<b>Application Ref:</b>	3/2026/0217			 <b>Ribble Valley Borough Council</b> <a href="http://www.ribblevalley.gov.uk">www.ribblevalley.gov.uk</a>
<b>Date Inspected:</b>	28/04/2026	<b>Site Notice:</b>	28/04/2026	
<b>Officer:</b>	MC			
<b>DELEGATED ITEM FILE REPORT:</b>				<b>REFUSAL</b>

<b>Development Description:</b>	Reserved matters application relating to appearance, landscaping, layout and scale following outline planning permission 3/2025/0289.
<b>Site Address/Location:</b>	Thornley Hall Farm, Up Bedlam Road, Thornley, PR3 2TN

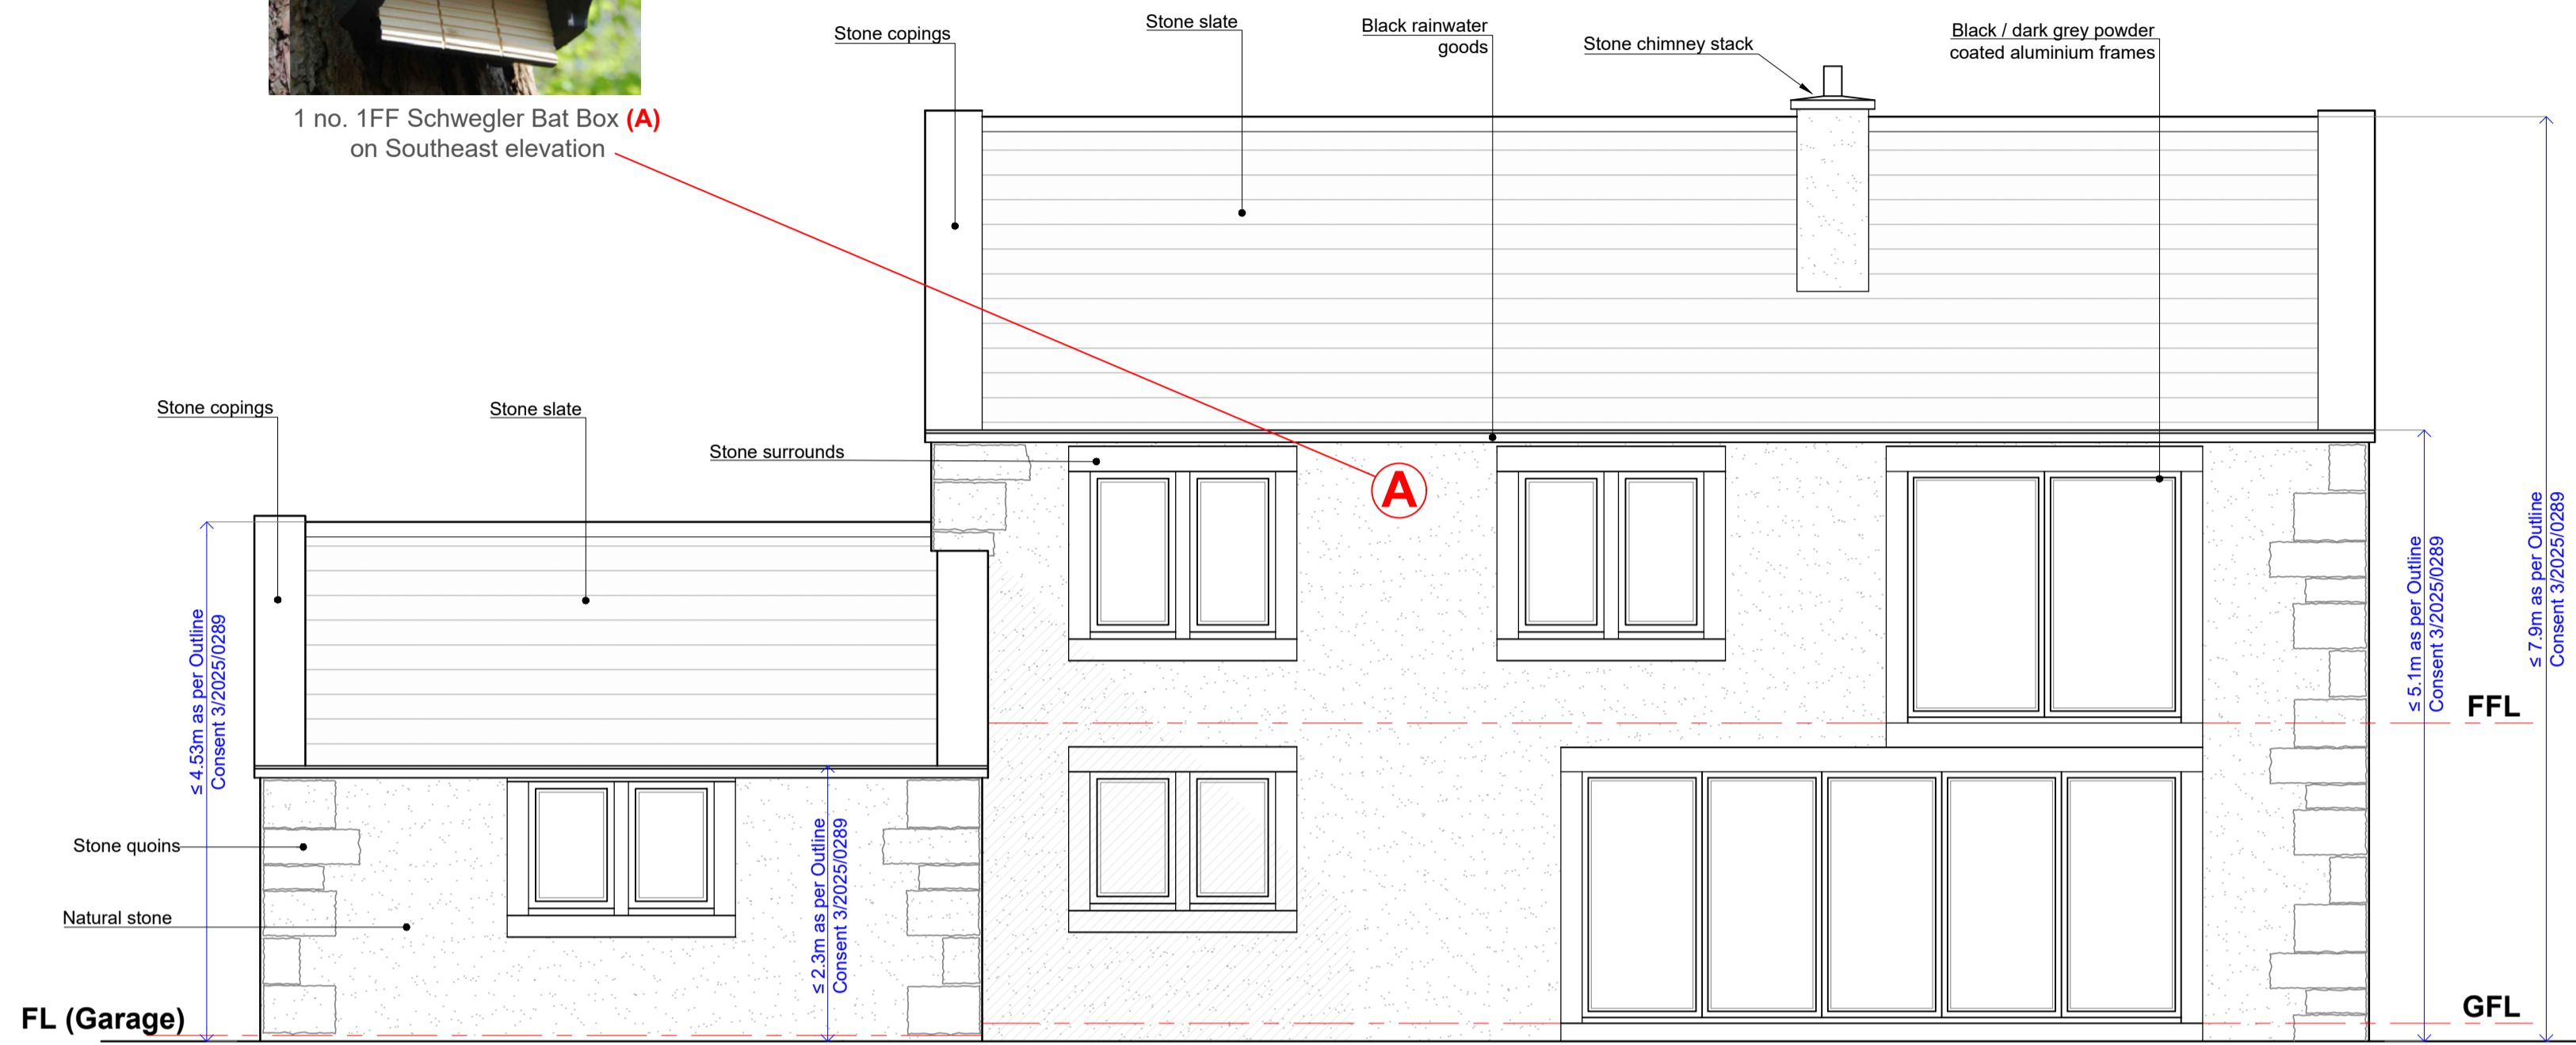
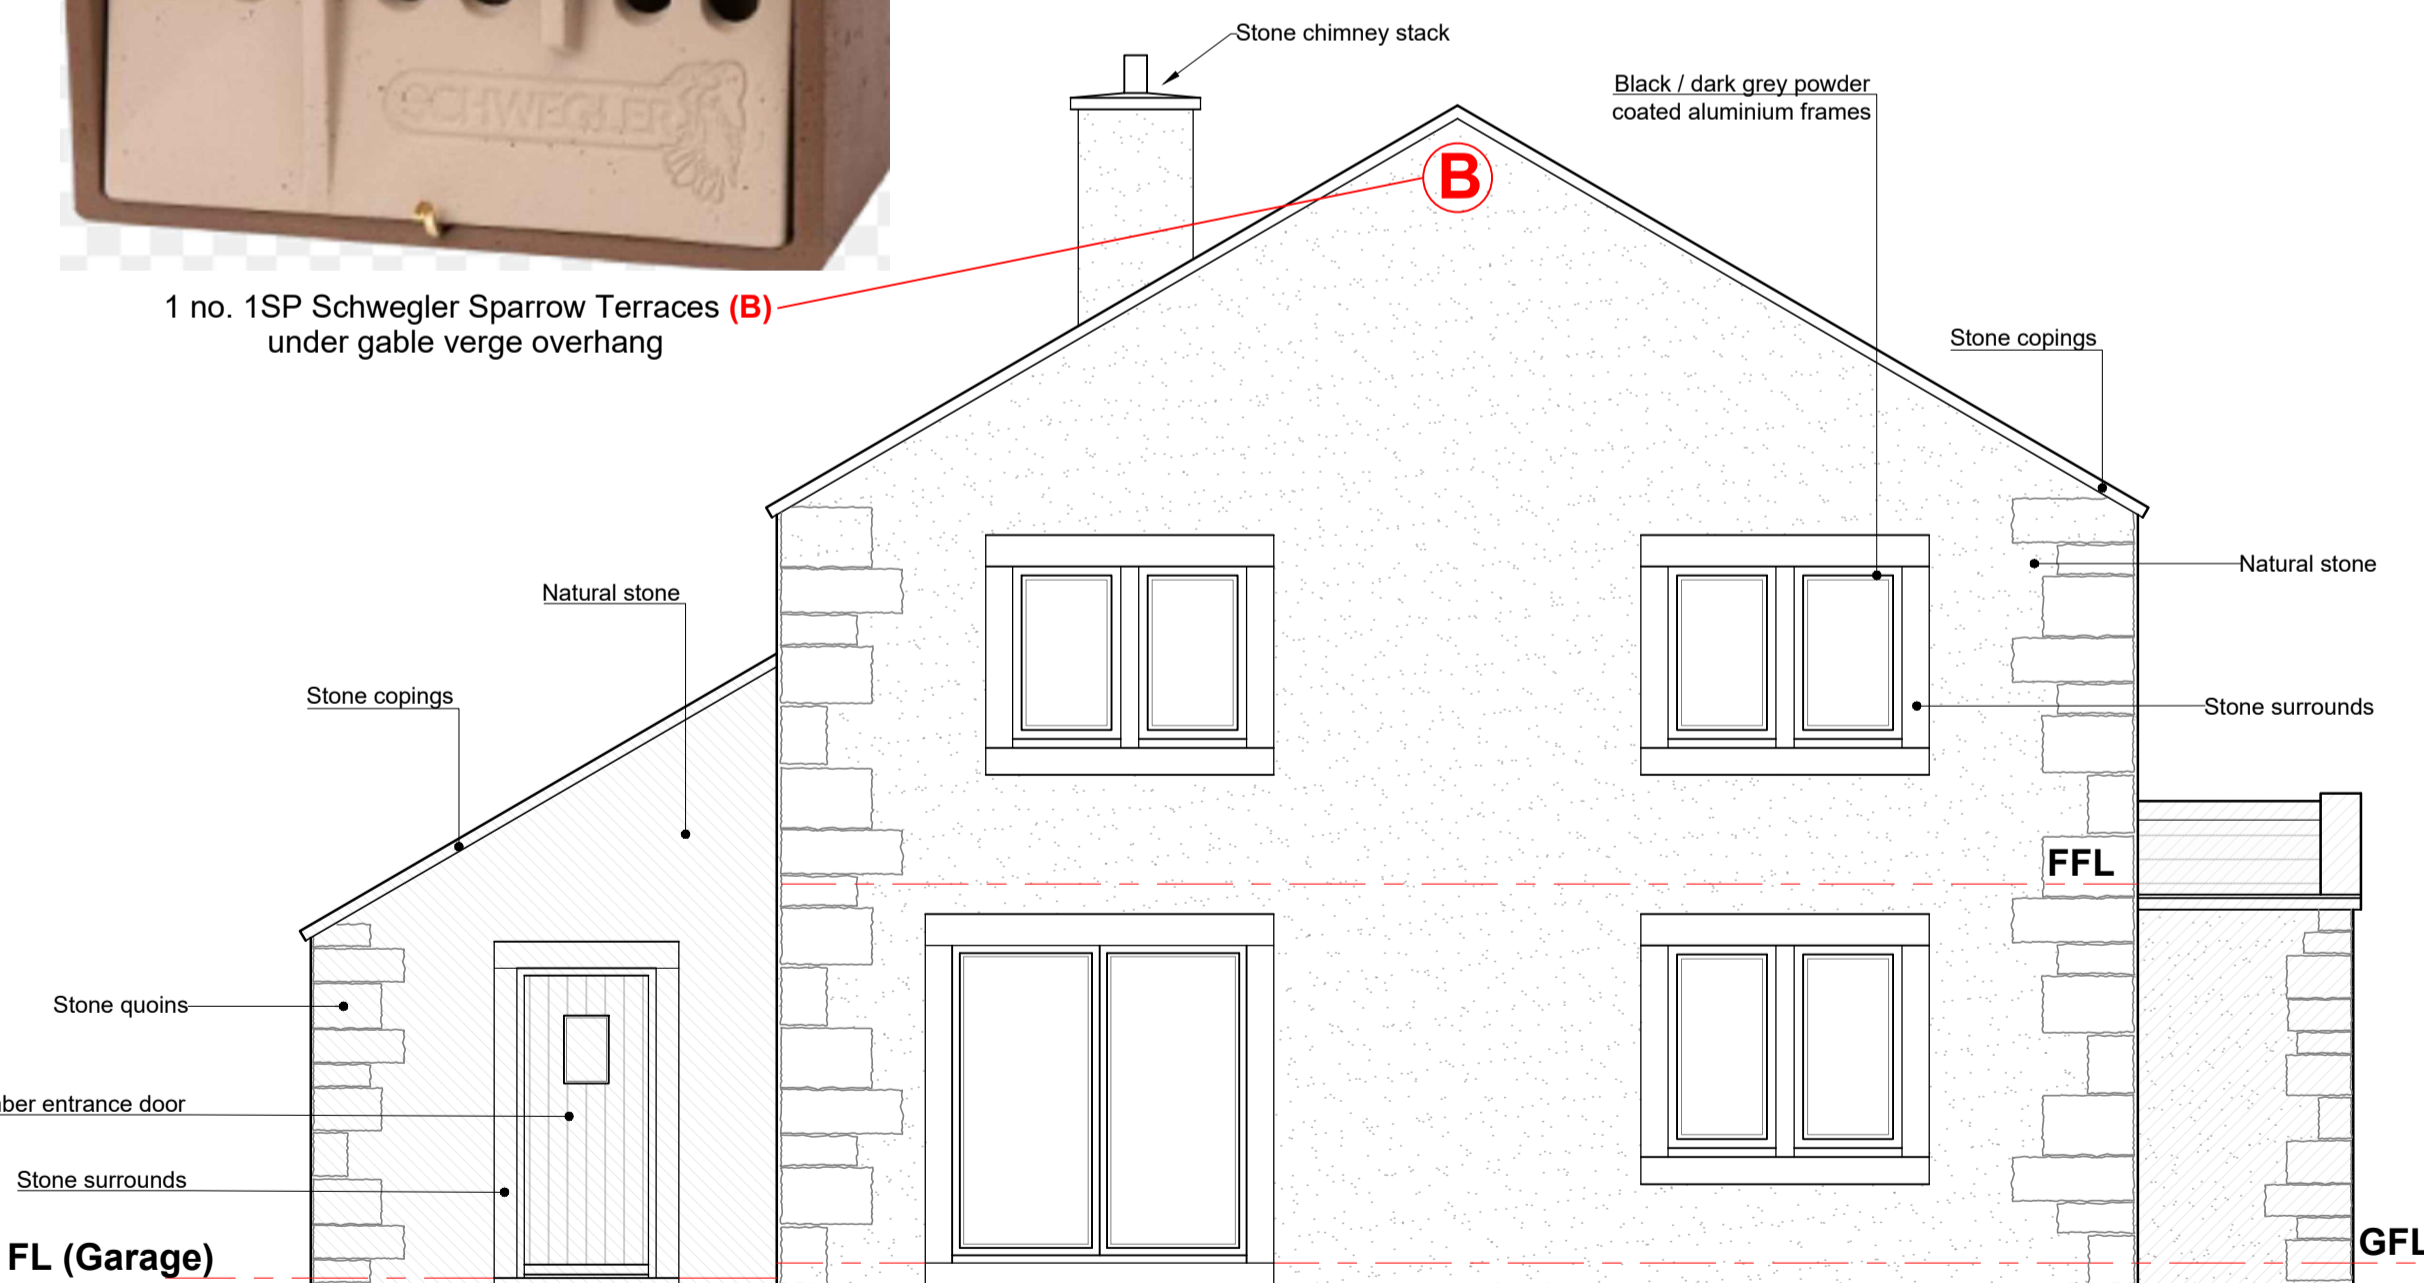
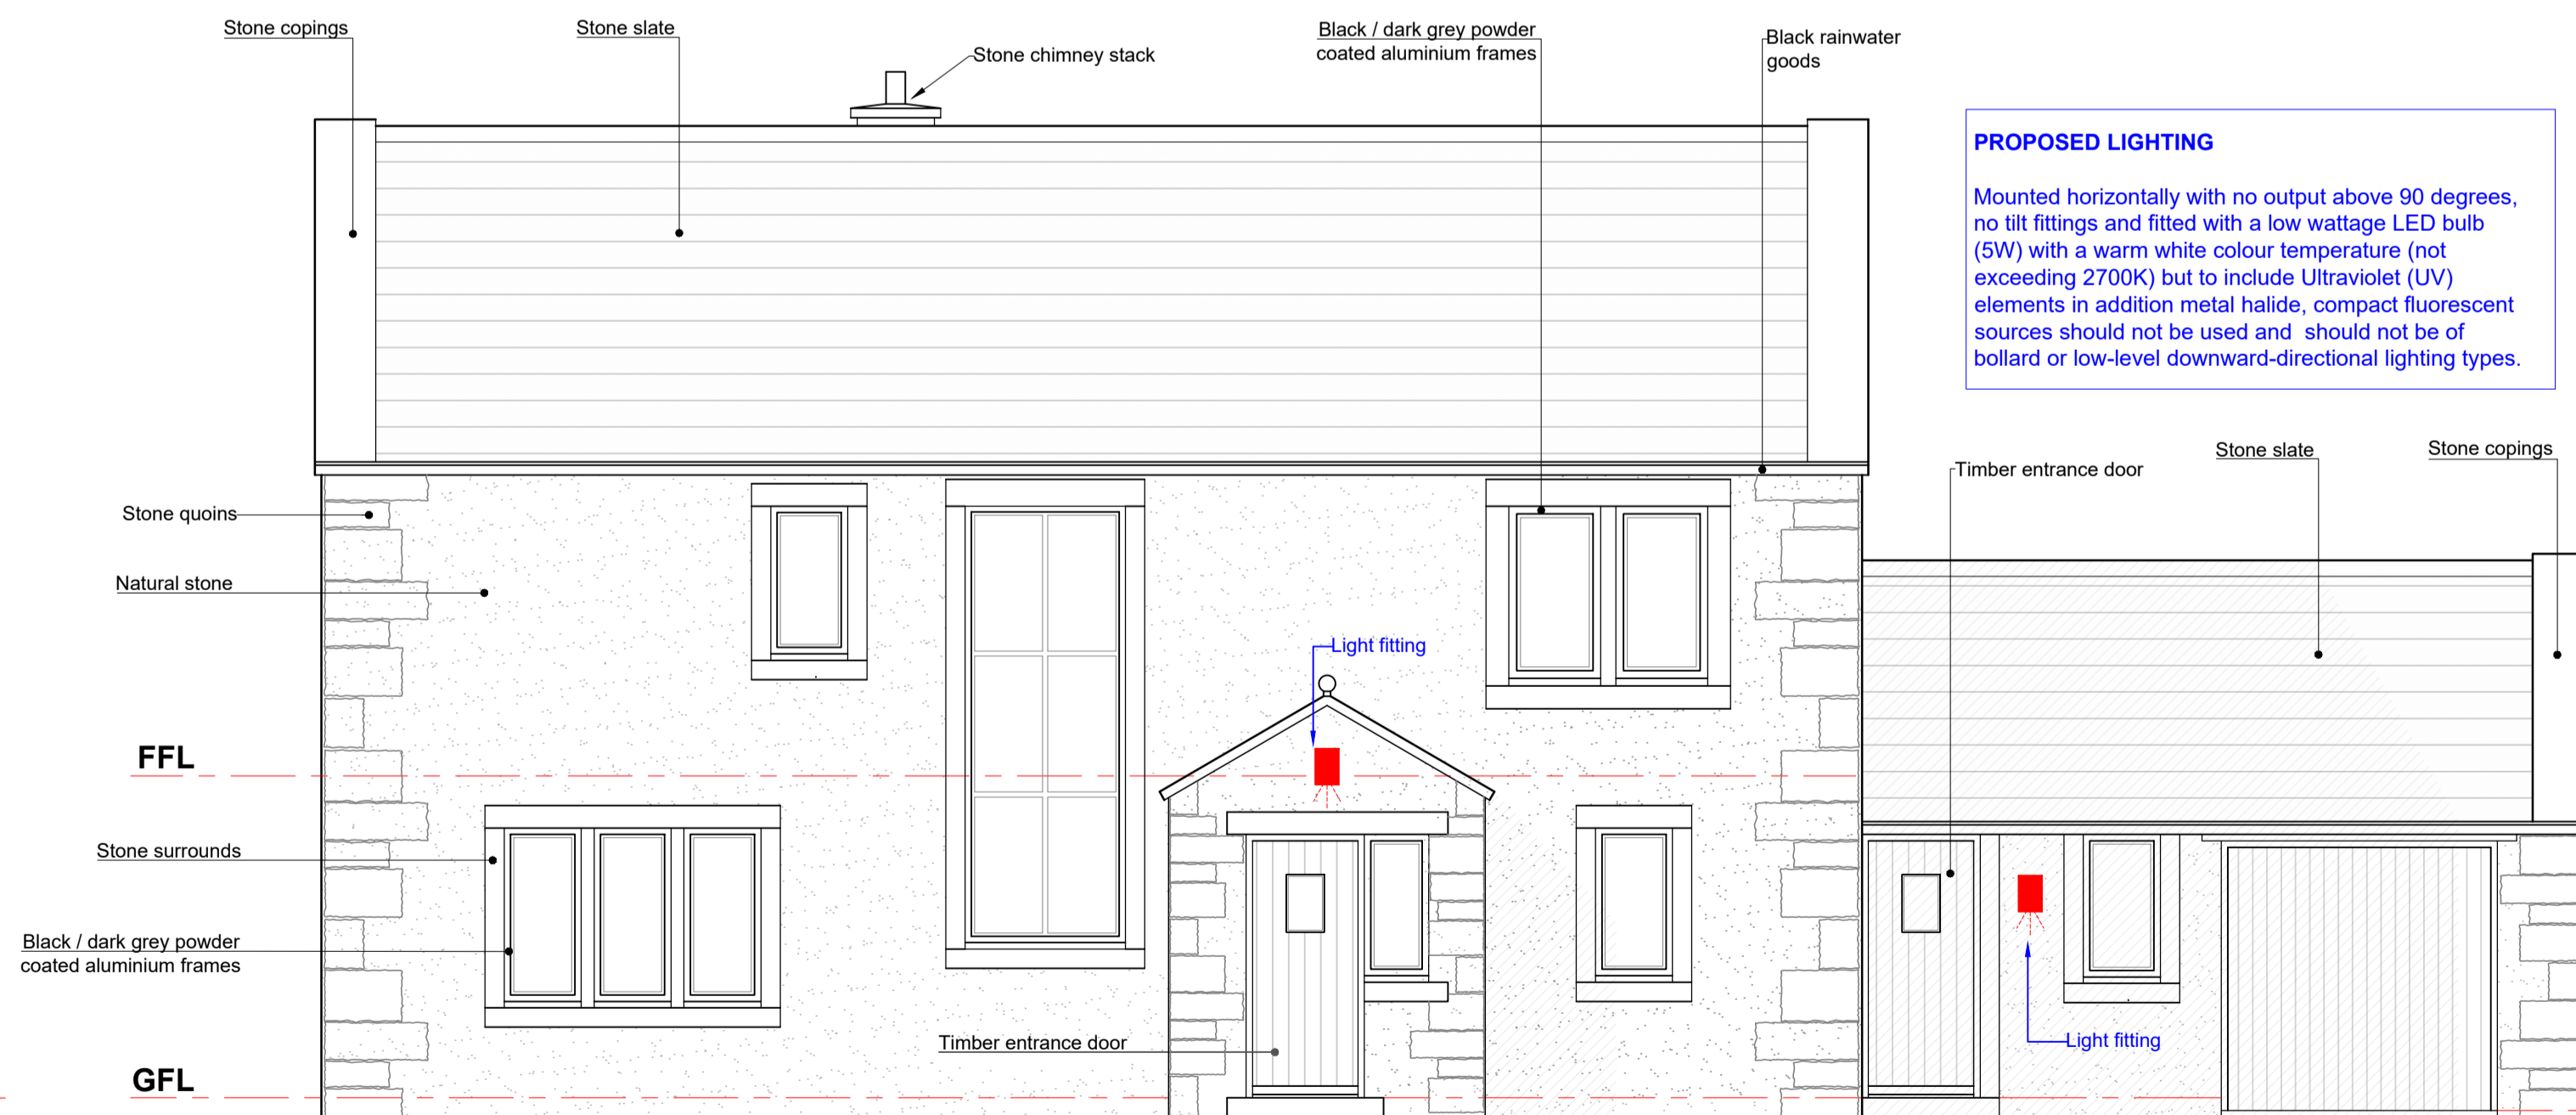
The previously approved orientation of the dwelling is considered to minimise the visual impact that would arise through the siting of a new two storey dwelling on this side of the road, without built form within its immediate vicinity. It aligns with the rear and side boundaries of the site, making efficient use of land, and is considered a more natural siting in the landscape, orientated so that its principal elevation is angled away from the highway and screened by trees which also allows for views across the site. A single storey garage element is positioned on the north-eastern side of the dwelling closest to the road which helps to break up the built form when viewed from the road. This stepped design helps to reduce the building mass as seen from the highway given the site elevation.

In contrast, the reorientation of the dwelling with the ridge running from east to west is not considered to be in keeping with the existing pattern of development within the vicinity of the site or relate well to its site boundaries. Due to its amended orientation, the dwelling would now appear more prominent in its surroundings and would reduce the open views through the site from the road. The two-storey principal frontage would be forward of the single storey garage element and would run across the site parallel to the road resulting in a greater scale and massing evident from the road. The fenestration detailing facing the highway also contributes to a greater prominence, including large feature landing window - in contrast the previous scheme had fewer and smaller windows facing the highway. Additionally, the proposed finished floor level is slightly higher compared to the previously approved scheme. The linear form of landscaping proposed in front of the dwelling is more contrived compared to the previous grouping of trees secured. The resultant changes are considered to result in a design which does not respond sympathetically to its surroundings, in particular a prominent building elevated from the road with reduced views across the site.
